drawing **PROPOSED OUTBUILDING
CONVERSION, E & F**

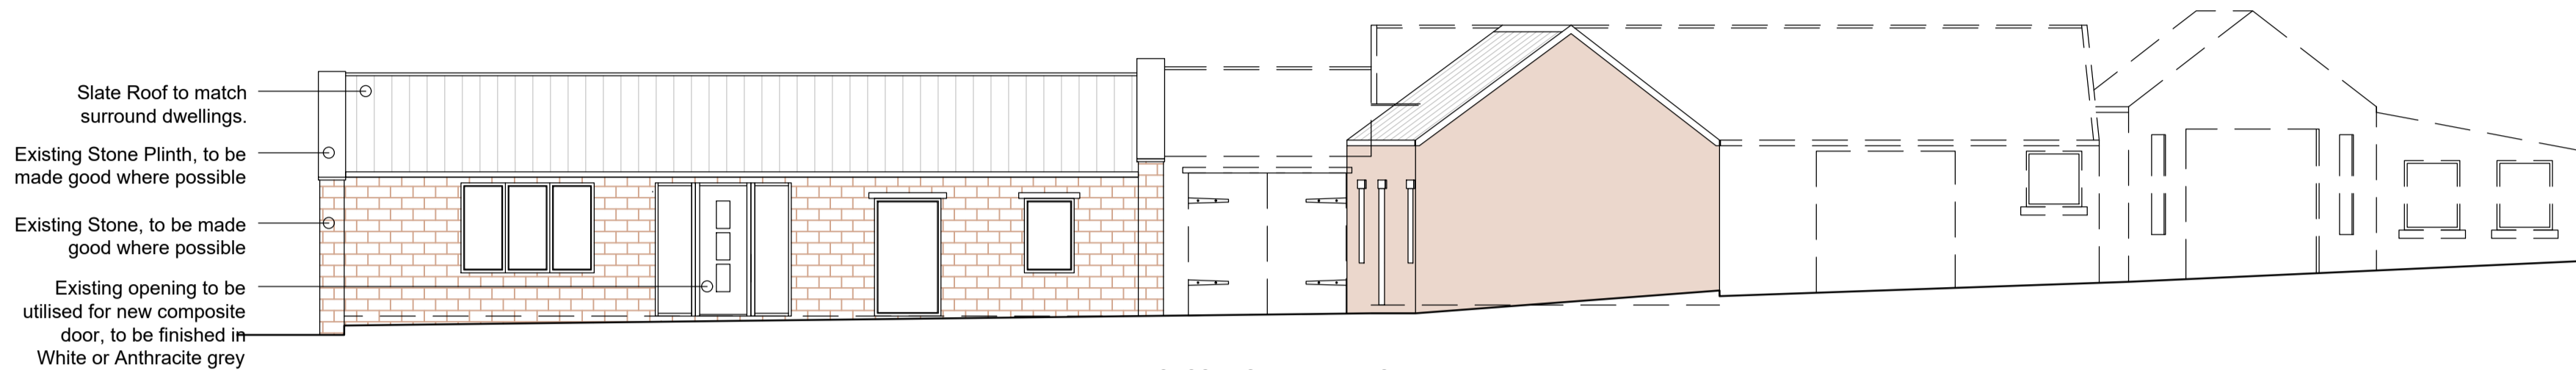
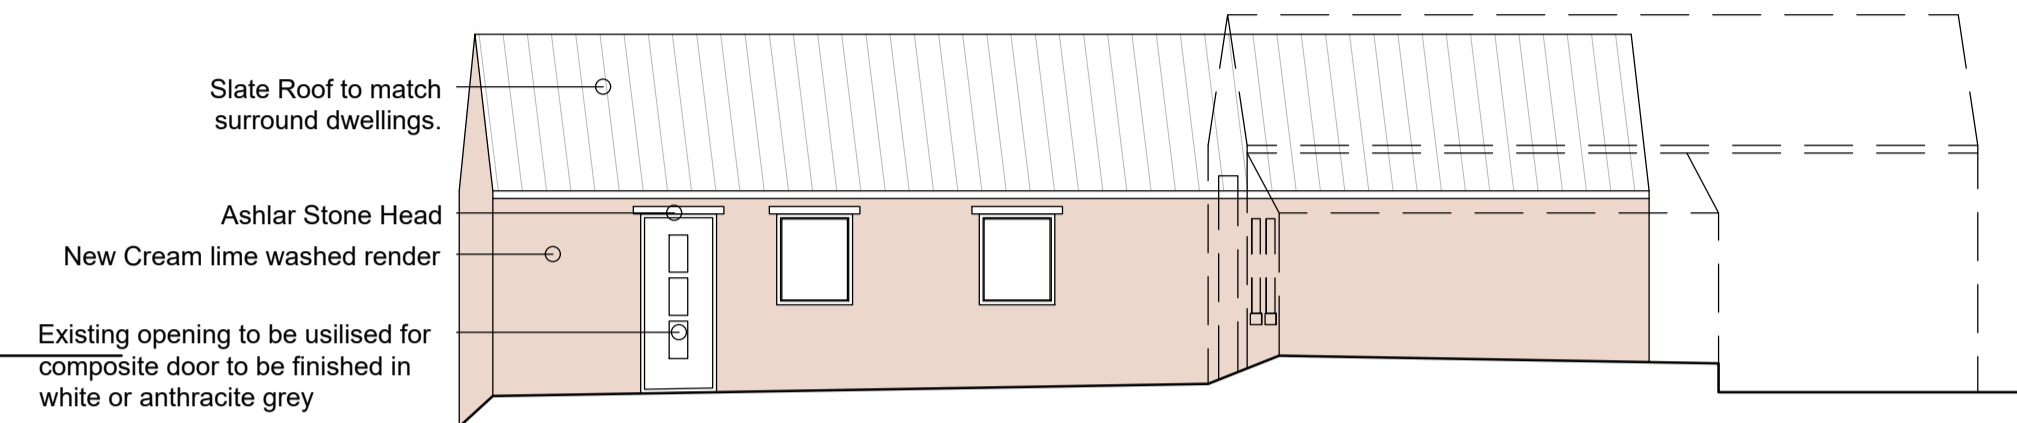
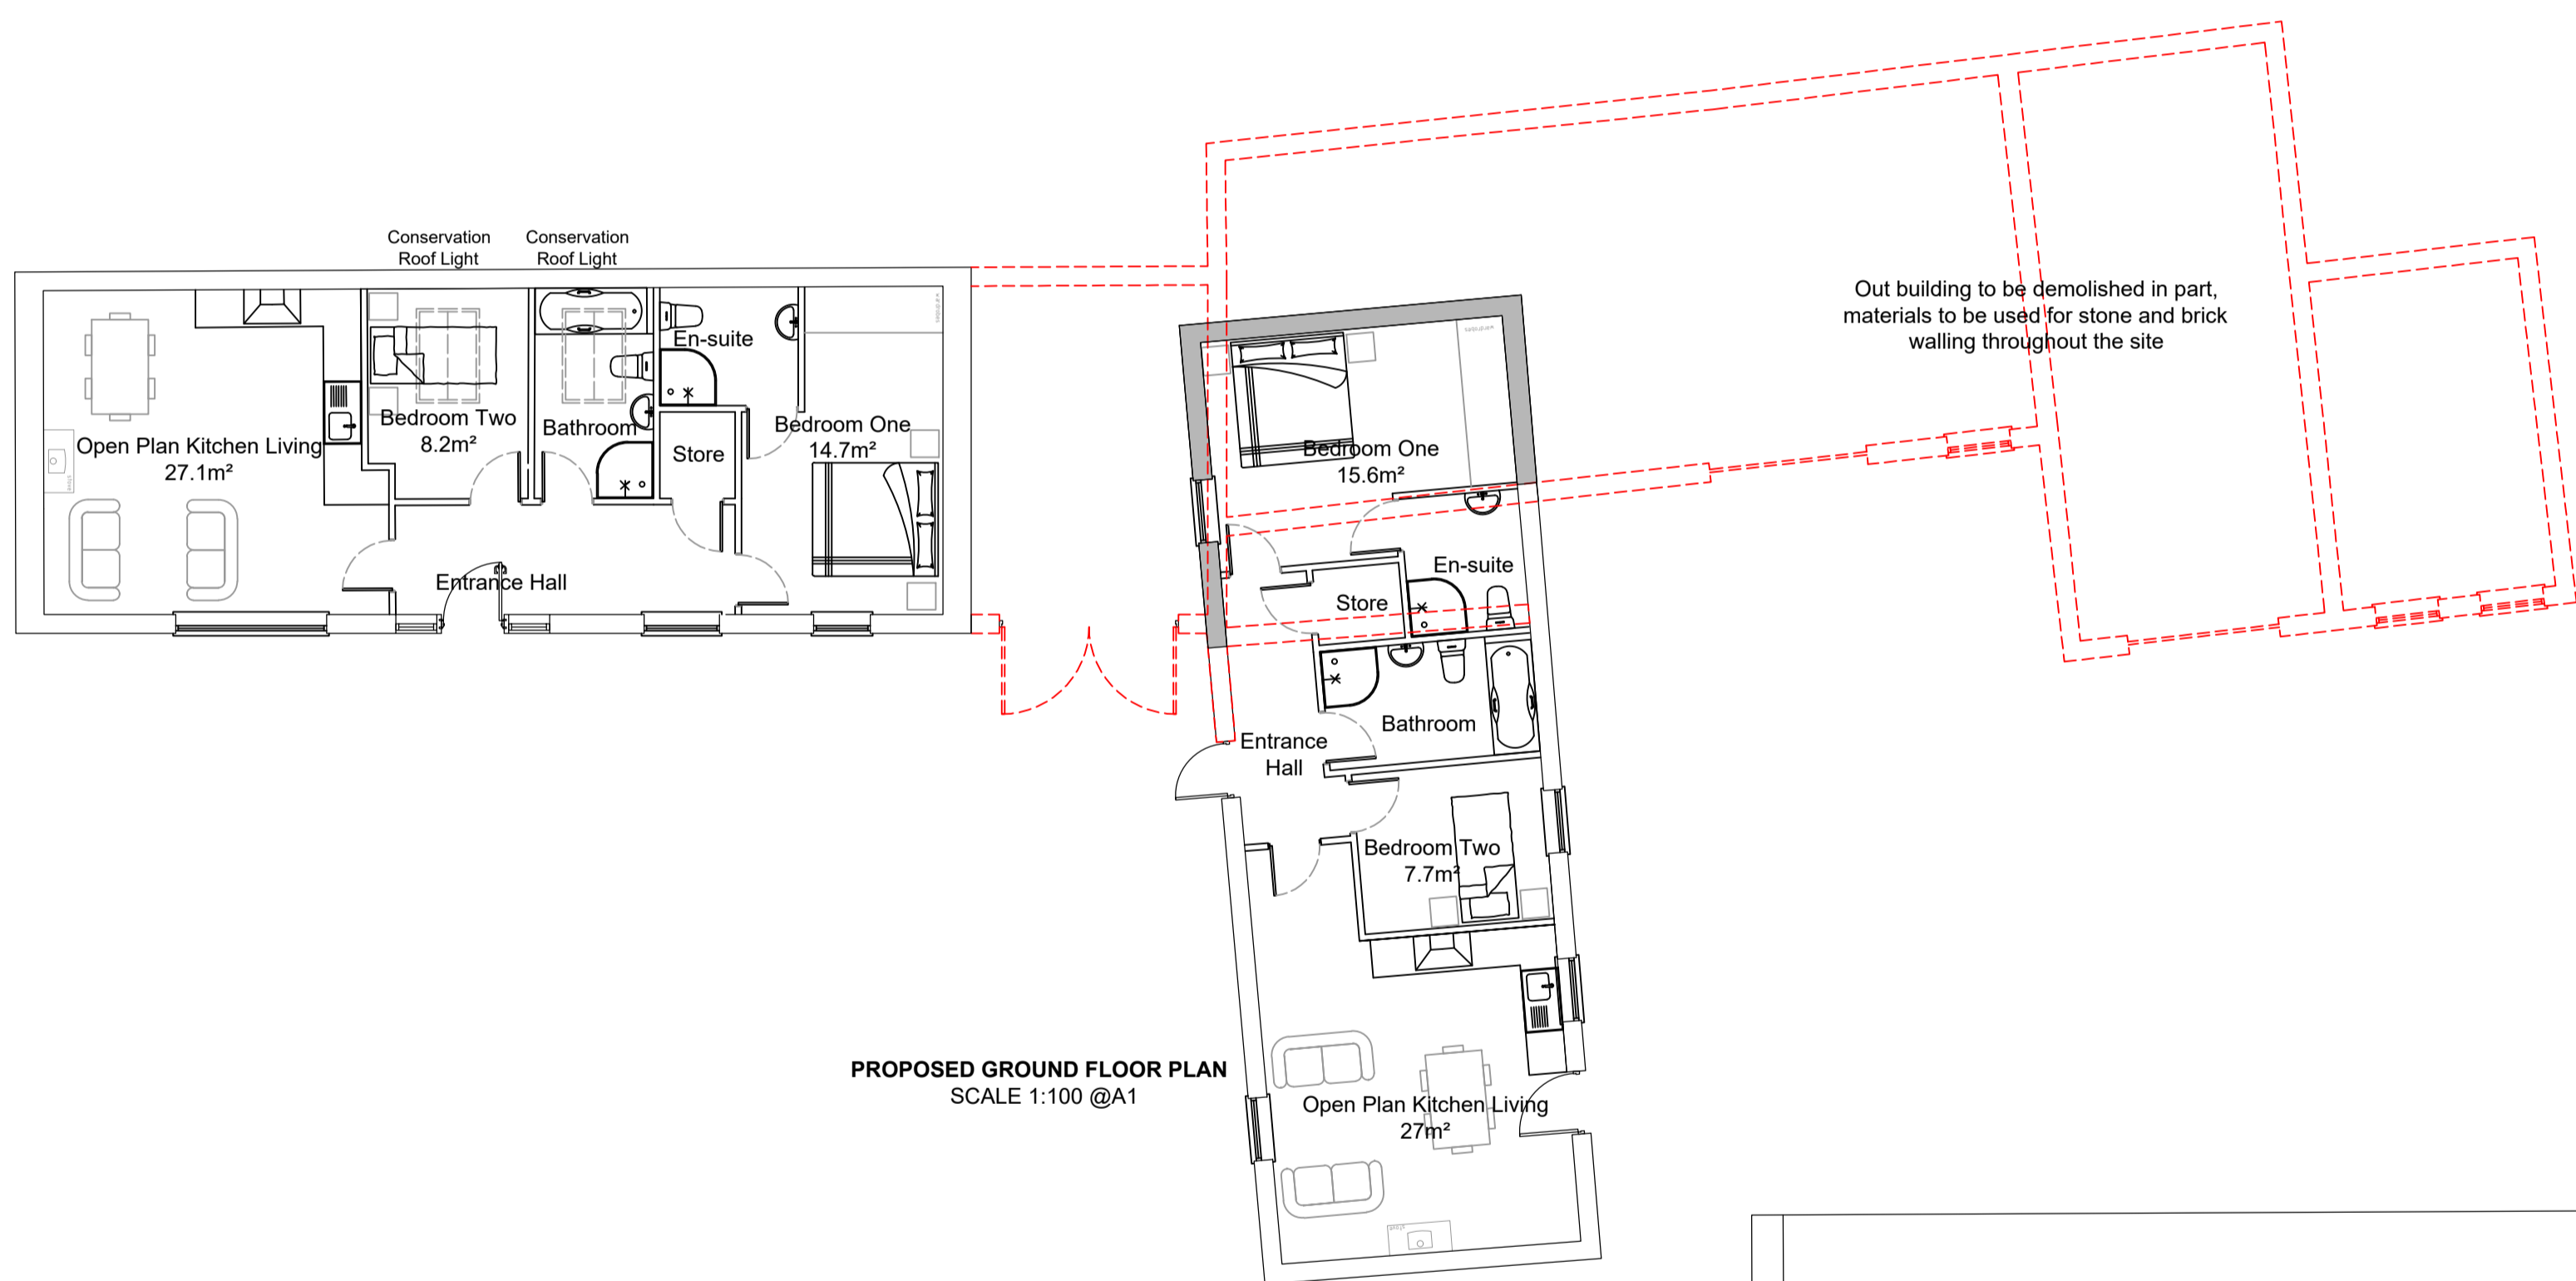
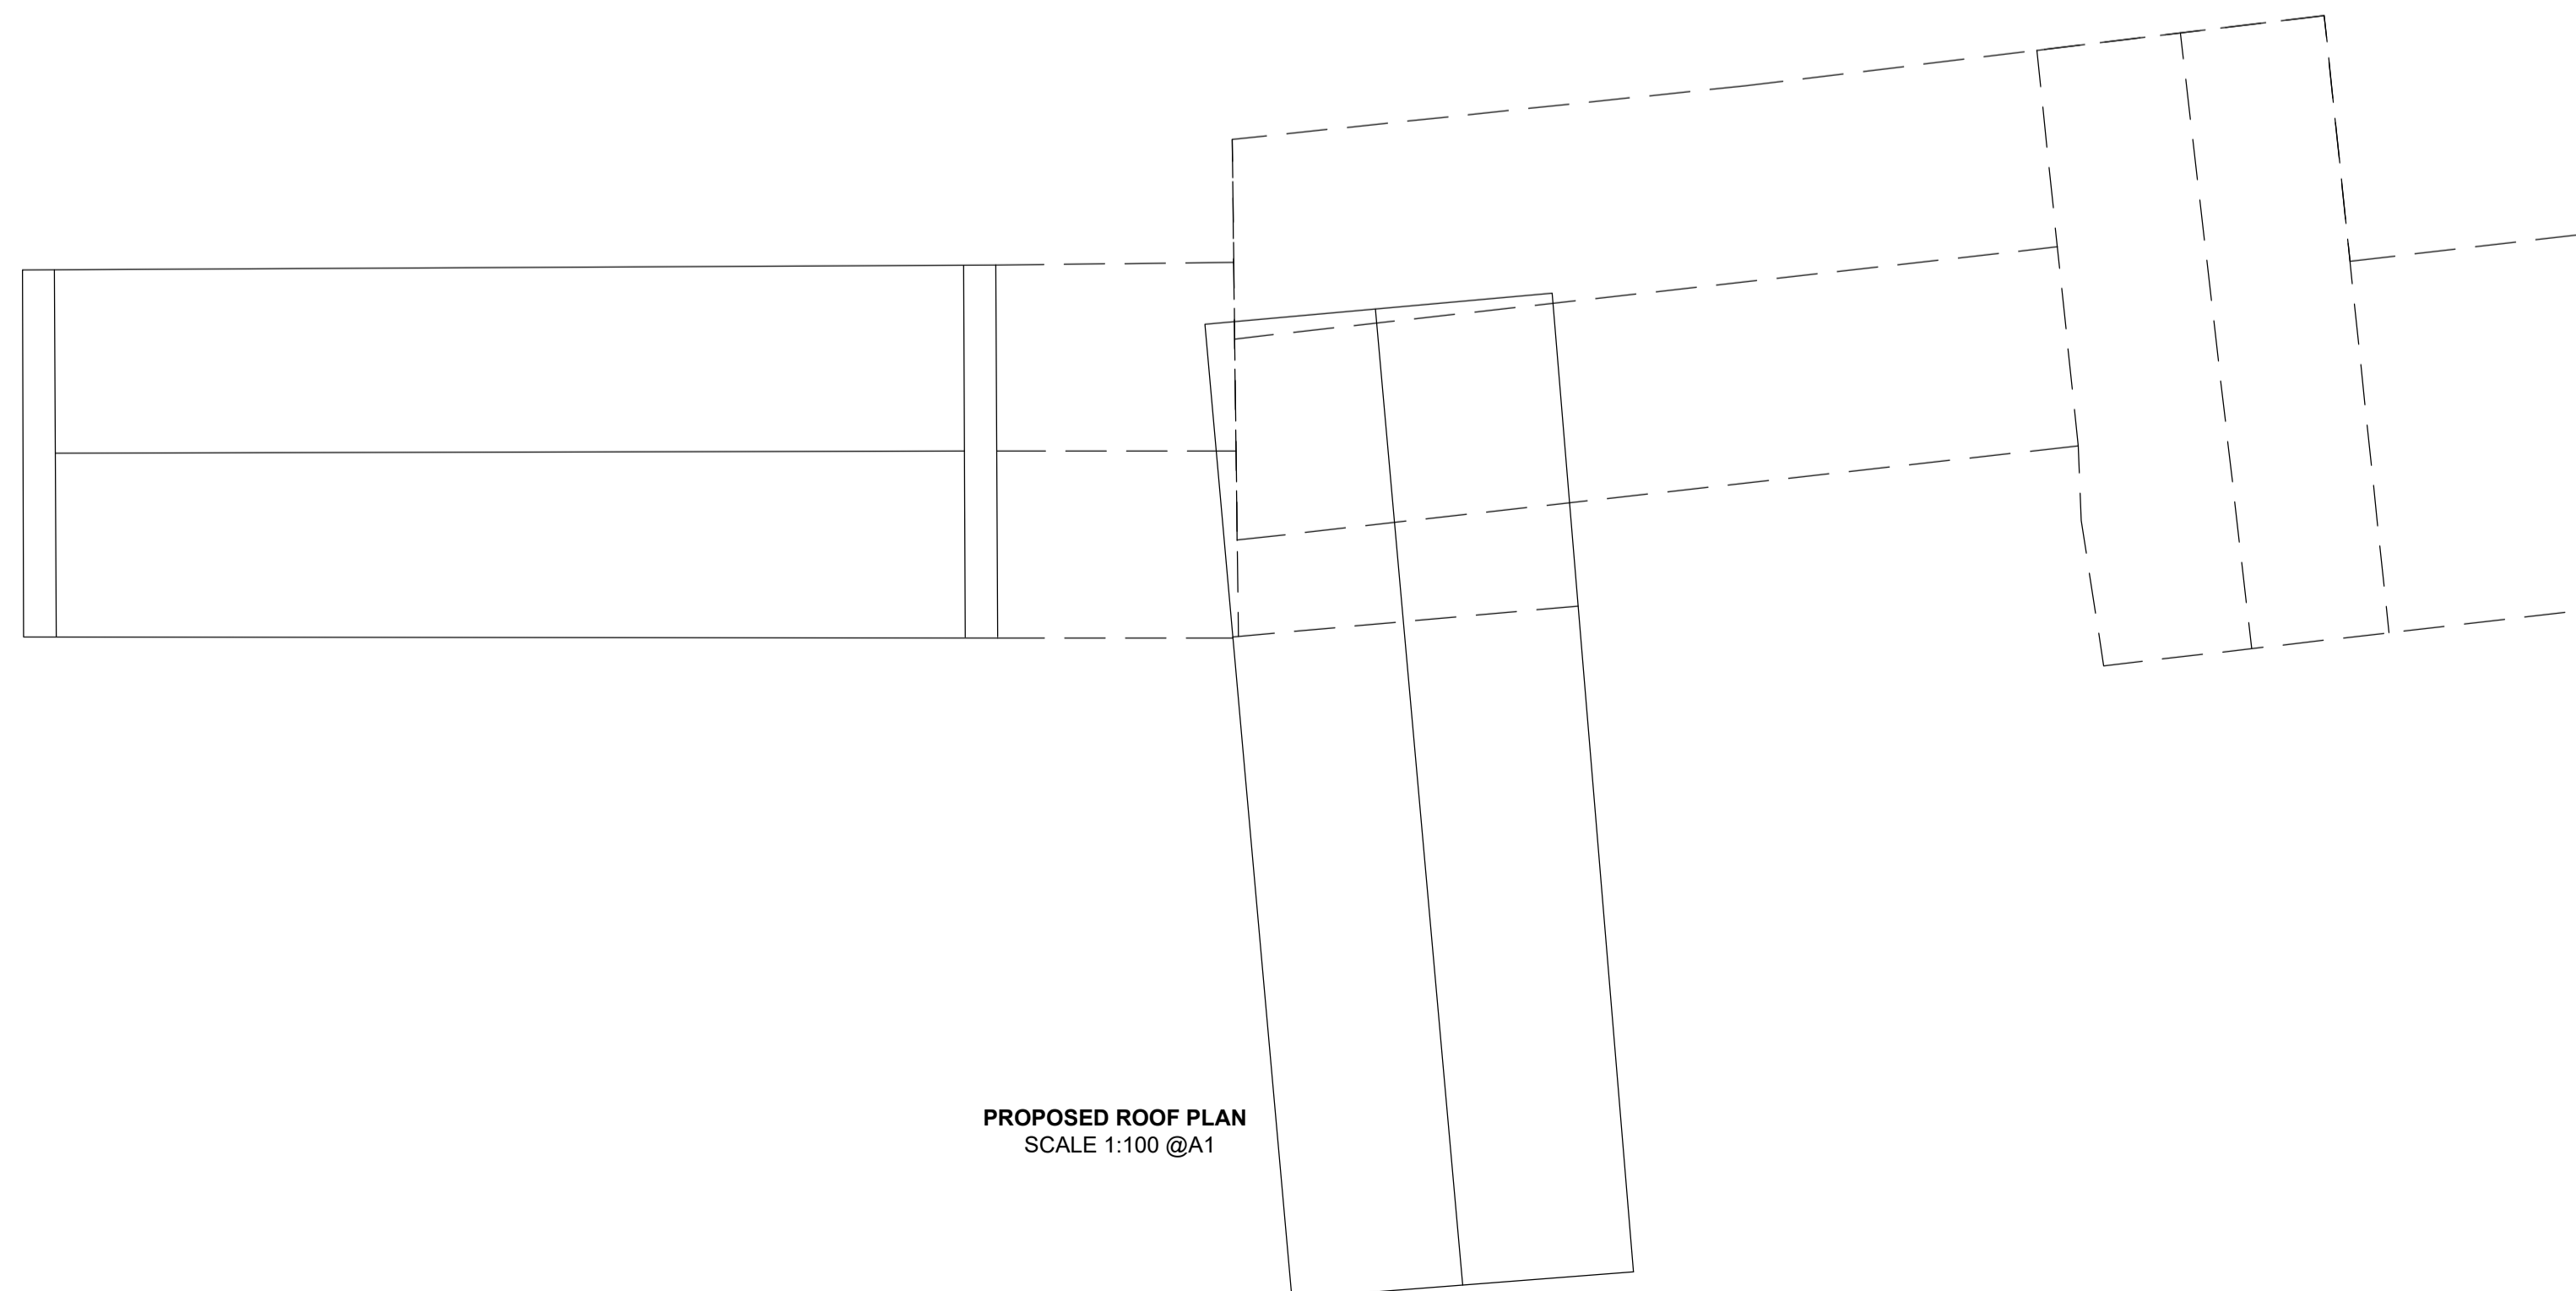
**Conservation Officer** – Further consultation with South Yorkshire Archaeology is required (consultation letter sent 9/5/2025). The existing buildings positively contribute towards the character of the conservation area. Concerns regarding the design of the proposed dwellings and the impact upon the historic character of the conservation

area. Therefore, amendments required, explore redeveloping the existing barns to created attached/terrace properties and use of traditional materials. See full comments attached.

Update to the scheme inline with Conservations officers comments, any existing stone work from existing building on site to be used as facades or natural stone walling as indicated on the proposed boundary treatment drawing and revised house type, along with more traditional feature added to the front Dwellings.
